**RE: PJ's Motorcycle Additions
12910 Central Ave SE
Grading & Drainage Plan
Engineer's Stamp Date 3-16-16 (Revised 4-11-16) (File: L22D059)**

From: Abiel X. Carrillo
Sent: Friday, April 08, 2016 12:55 PM
To: 'CCEAlbq@aol.com'
Subject: L22D059 - PJ's Motorcycle Site Expansion - 3-16-2016 Stamp Date

Based upon the information provided in your submittal received 3-18-2016, the above-referenced Grading and Drainage Plan cannot be approved for Building Permit until the items below are addressed:

Grading & Drainage  
Plan

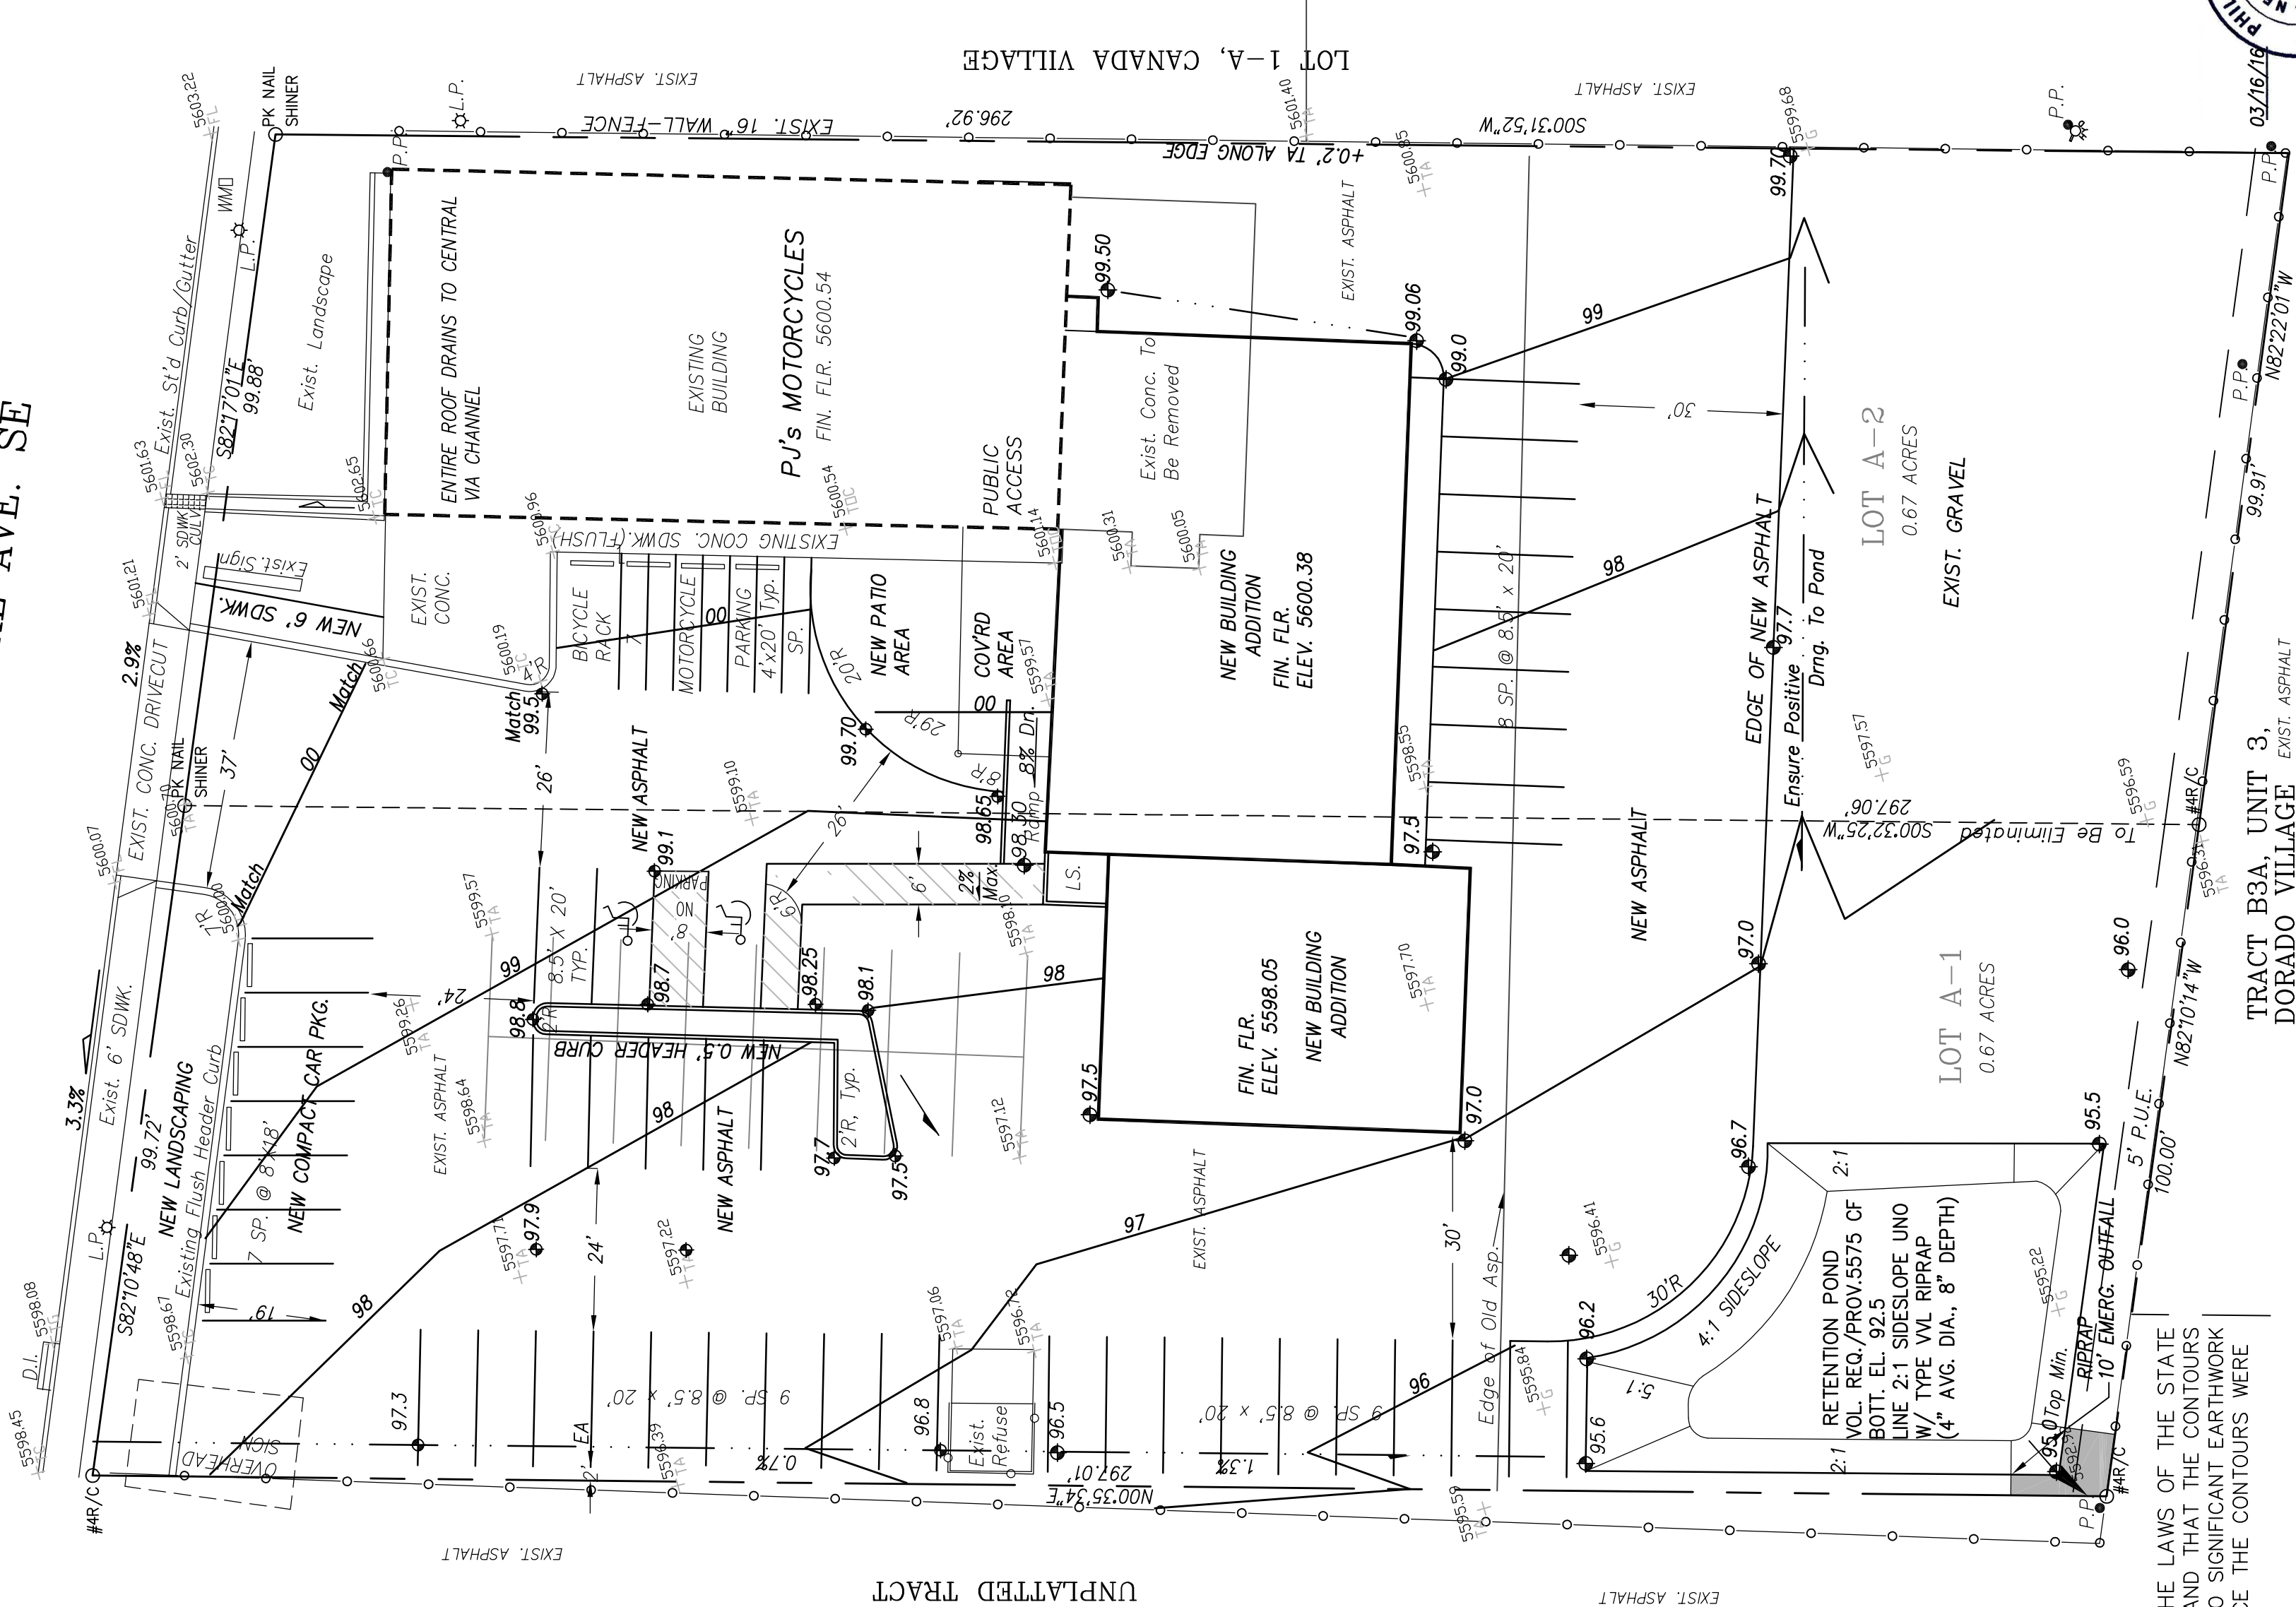
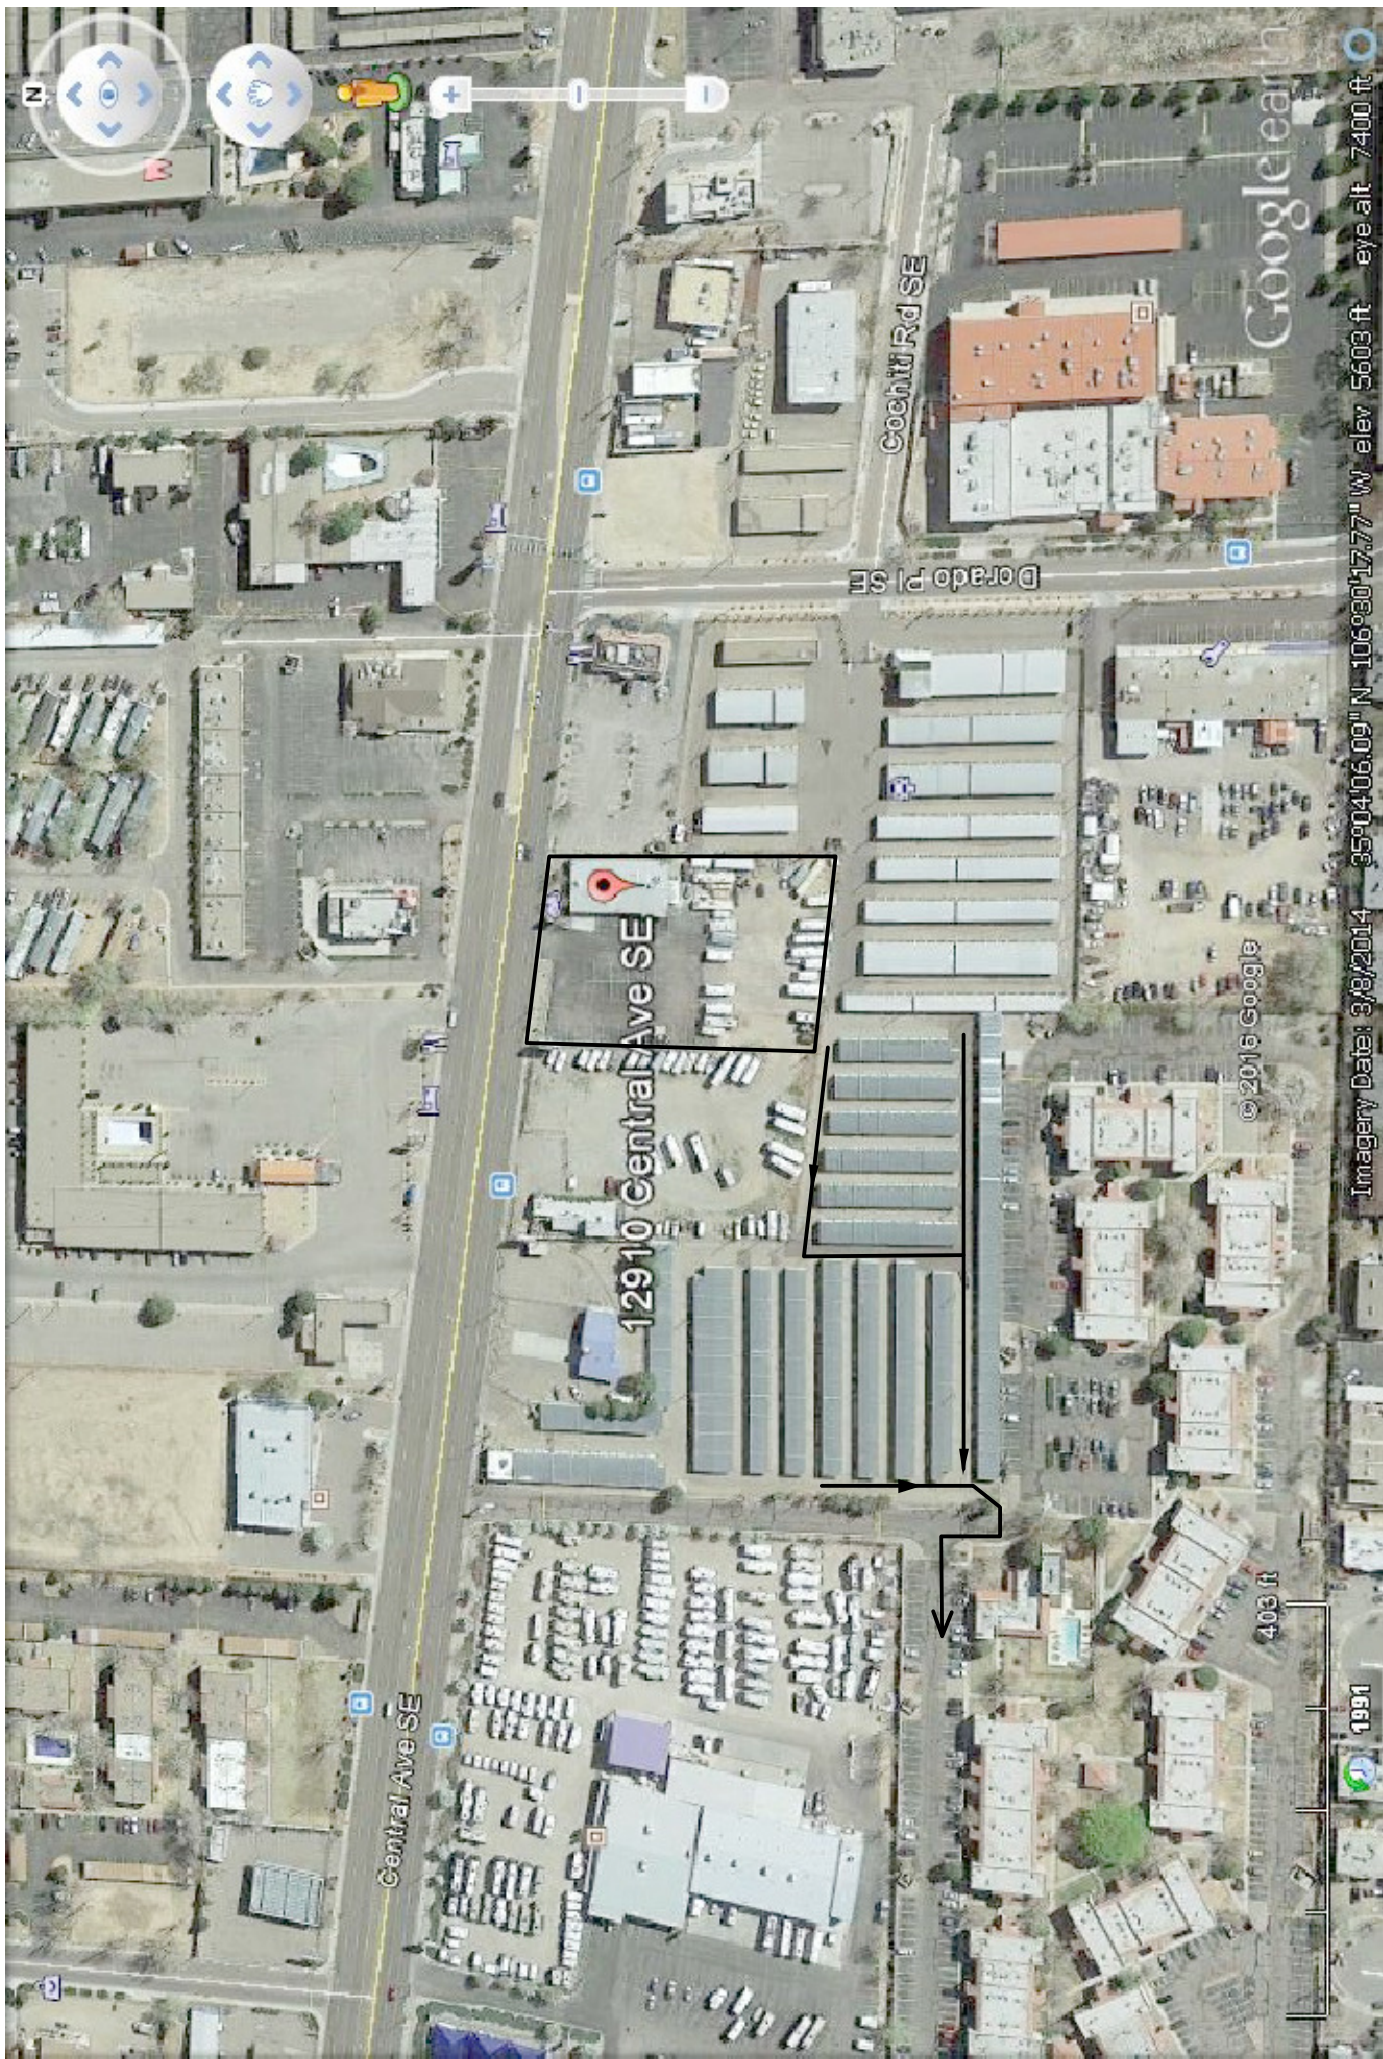
1. The concept of the plan is acceptable, but the hydrology calculations need to be updated as follows:
 - a. DESIGN CRITERIA: The site is in Zone 3 not Zone 4, which will help reduce the 'historical flow' being released.

- b. EXISTING CONDITIONS: The site is analyzed with 100% Land Treatment A, which is not correct, half of the lot is developed.
 - c. DEVELOPED CONDITIONS: The calculated 100-yr volume does not appear to be correct.

- d. FIRST FLUSH: Although the pond is expected to manage the first flush volume in its entirety, please be aware for future reference that the first flush is calculated by taking the impervious area and multiplying by 0.34" (0.44" per the Ordinance minus 0.1" for initial abstraction).

2. The pond should retain the 100-yr, 6-hr design storm, which is approximately 8350 CF (by my calculation using your land treatment numbers). If you are not able to meet that volume, justify on the plan. Fortunately, it appears that the peak flow will actually be lowered since you are retaining more than half the design storm.

3. We recommend using a "recoverable" slope along the edge of the pond that is next to the driving lane (Not a hydrology requirement, just a recommendation).

Settled on capturing
about 60% of the
hydrograph.
SS 75 CF.
